From: [Bryan Bobrick](#)
To: [Harmon Rita T.](#)
Subject: Re: FW: Following up from Friday regarding Penguin Chill plans
Date: Friday, October 07, 2016 11:33:42 AM
Attachments: [image001.png](#)

Please see the attached approval letter from Hydrology, pending a condition that WUA will accept the drainage from the trench drains.

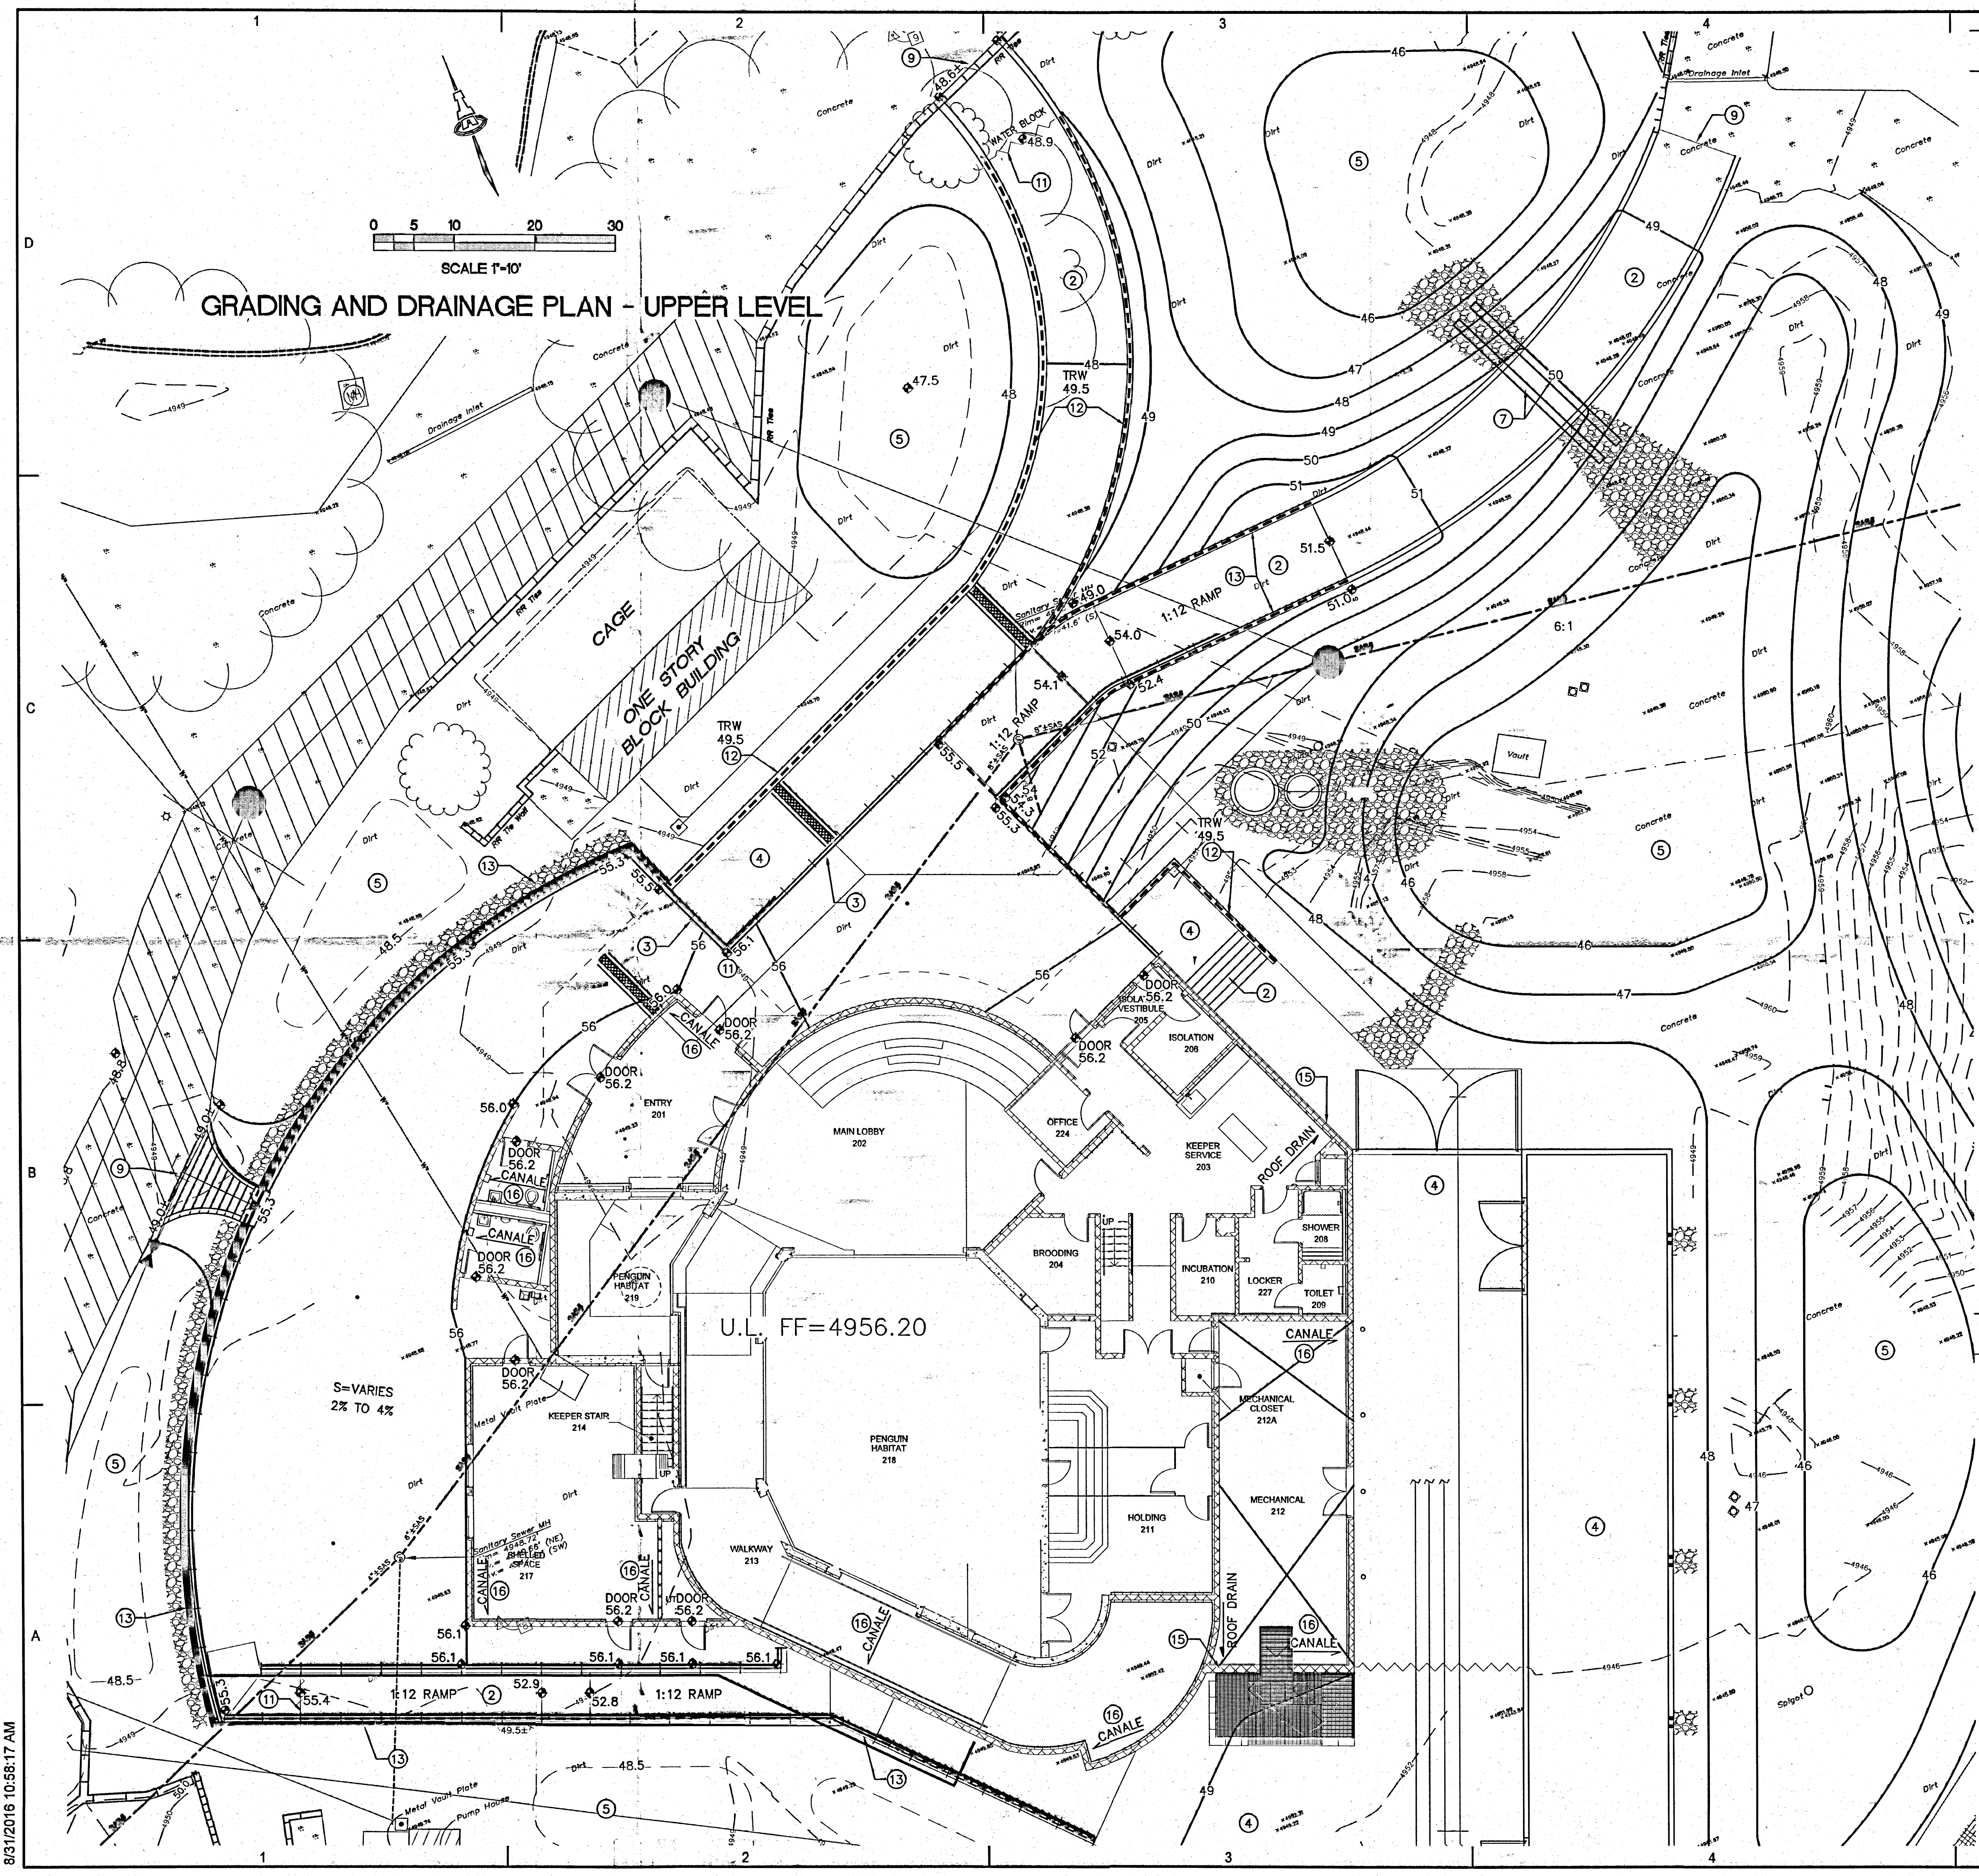
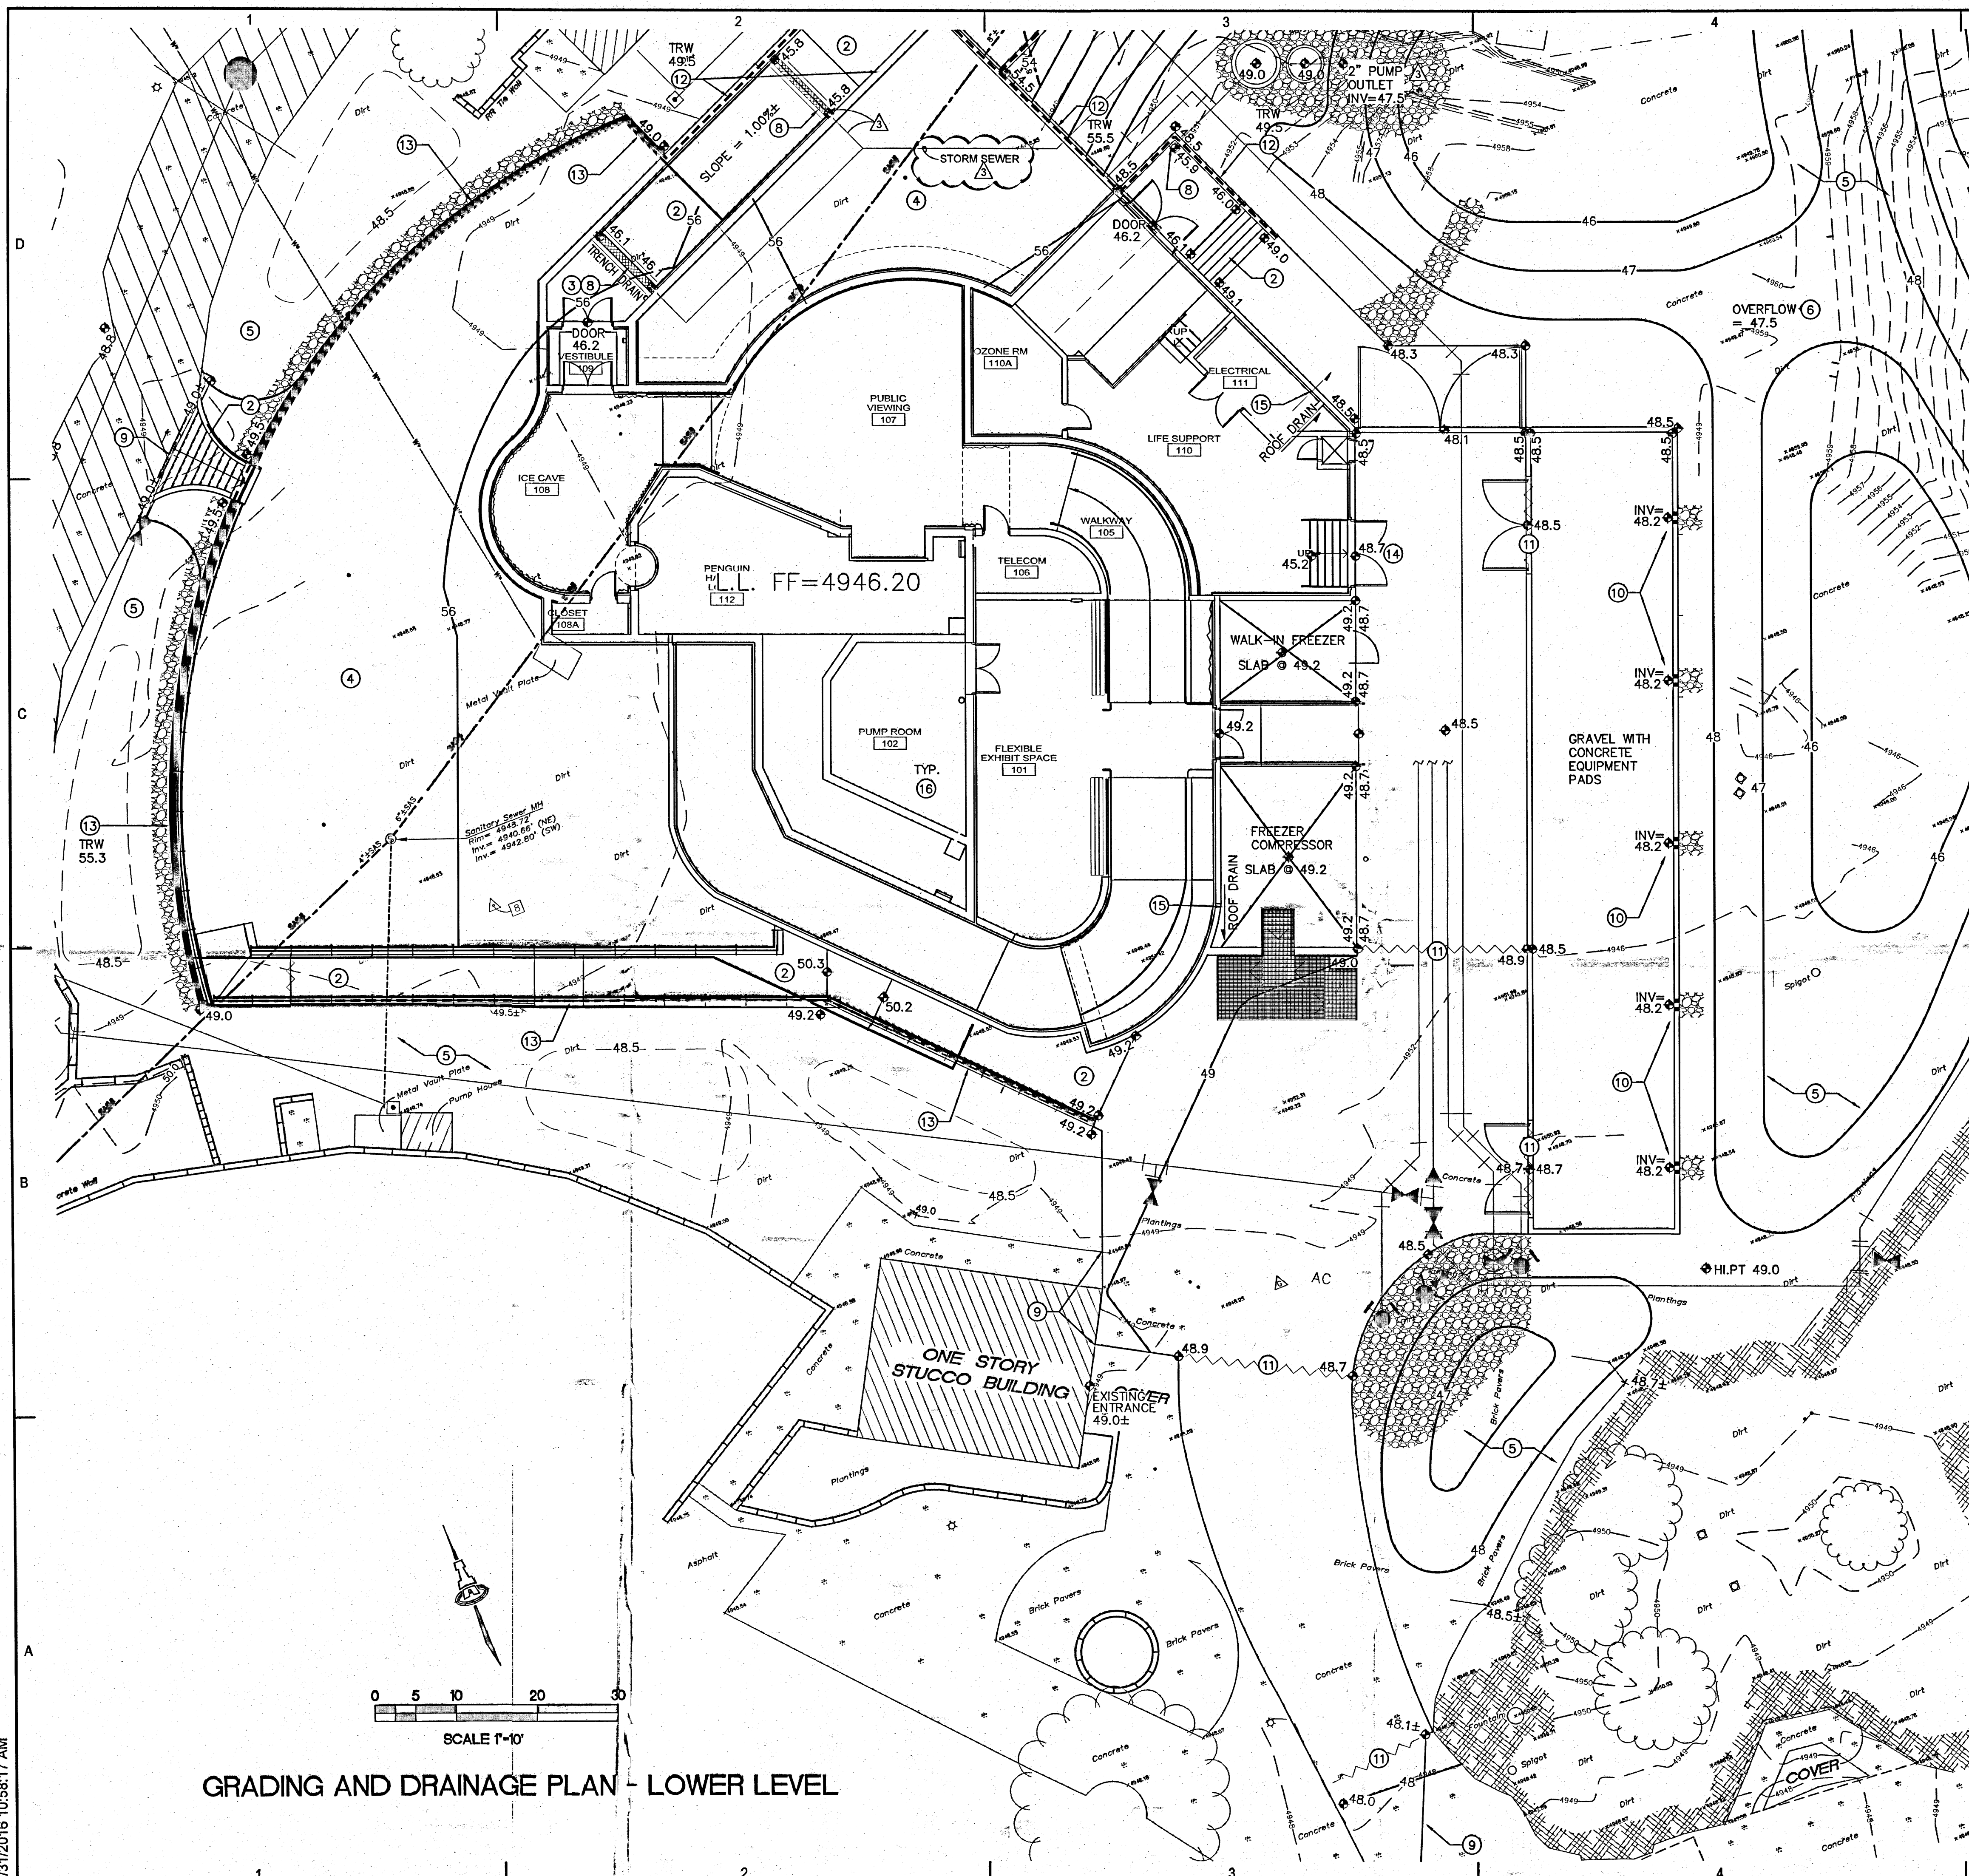
Additionally, the Building Permit process will be complicated if the retaining walls are shown partially on the architectural plans, and partially on the Civil plans. It would be better to show all retaining walls on the Civil plans.
